From: Thomas Callaway
Sent: 18 May 2015 11:36
To: Planning.Responses
Subject: RE: Planning Consultation on: EG/31/15/HH

Engineers comments in respect to surface water drainage:

APPLICATION NO: EG/31/15/HH

Description of Works: Side & rear extensions & conversion of bungalow to house

PROPOSED ROOF PLAN 1/100

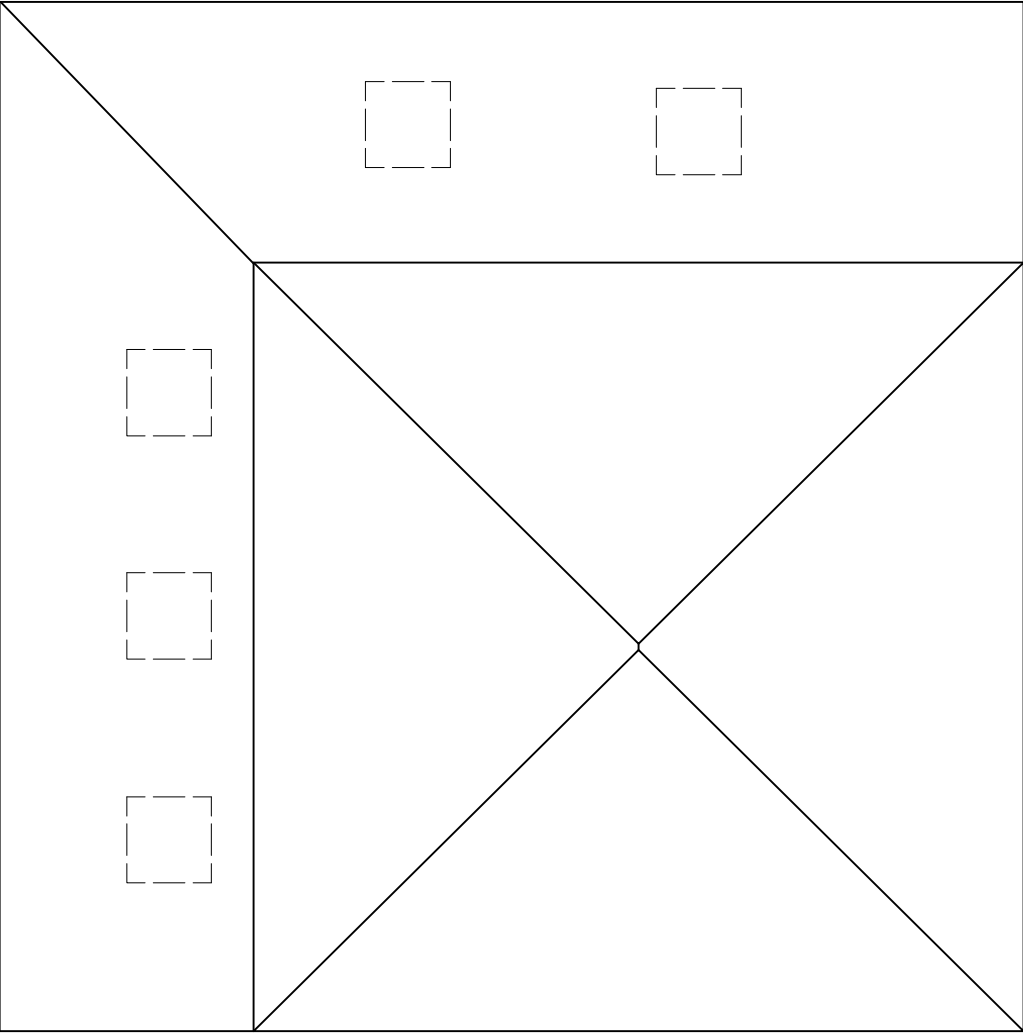
Surface water drainage should be provided for all new roof areas, prioritising infiltration.

Infiltration rates for soakage structures are to be based on percolation tests undertaken in the winter period and at the location and depth of the proposed structures. The percolation tests must be carried out in accordance with BRE 365, CIRIA R156 or a similar approved method and cater for the 1 in 10 year storm between the invert of the entry pipe to the soakaway, and the base of the structure. It must also have provision to ensure that there is capacity in the system to contain below ground level the 1 in 100 year event plus 30% on stored volumes, as an allowance for climate change. Adequate freeboard must be provided between the base of the soakaway structure and the highest recorded annual groundwater level identified in that location.

Any SuDS or soakaway design must include adequate groundwater monitoring data to determine the highest winter groundwater table in support of the design. The applicant is advised to discuss the extent of groundwater monitoring with the Council's Engineers. Supplementary guidance notes are also enclosed for information.

Please apply standard conditions ENGD2A.
